## SHORELINE SUBSTANTIAL DEVELOPMENT PERMIT EXEMPTION

The applicant is placing a gazebo from another property onto this parcel

SX-22-00017

**RECORD OF SURVEY**  
 WITHIN THE SE1/4 OF THE SE1/4 OF SEC. 22, T.20N., R.14E., W.M.  
 LOTS 54 AND 55, BLOCK 4, ELK MEADOWS  
 FOR  
 RICHARD KLAUS

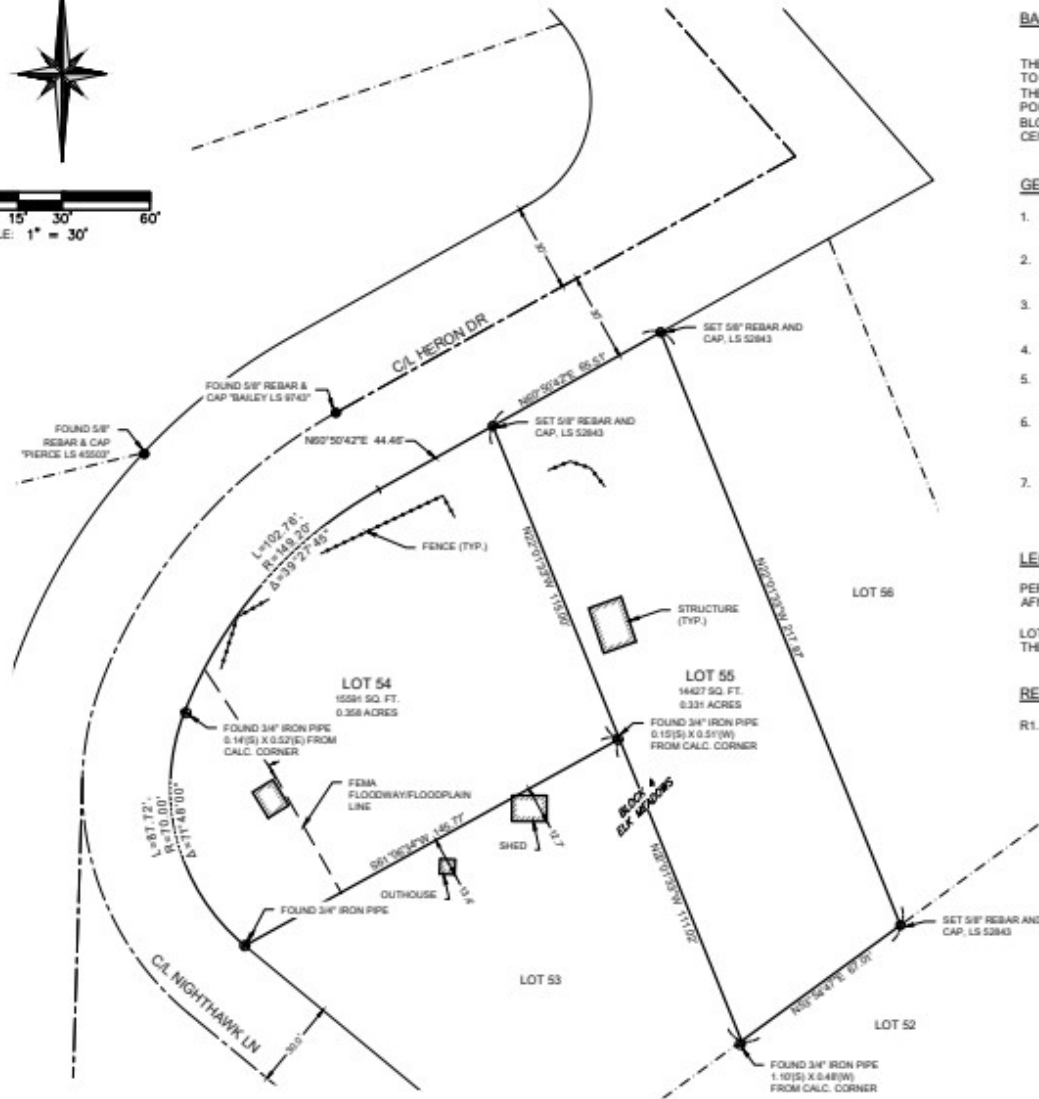
1. All work shall substantially conform to the specifications of the site plan and application materials submitted to Kittitas County Community Development Services by Richard Klaus on July 21, 2022 and survey submitted August 30, 2022 regarding floodway boundaries.

2. The floodway boundary must be marked by a licensed surveyor and gazebo can't be in any portion of the floodway.
3. A floodplain development permit shall be obtained from Kittitas County Public Works for the gazebo.
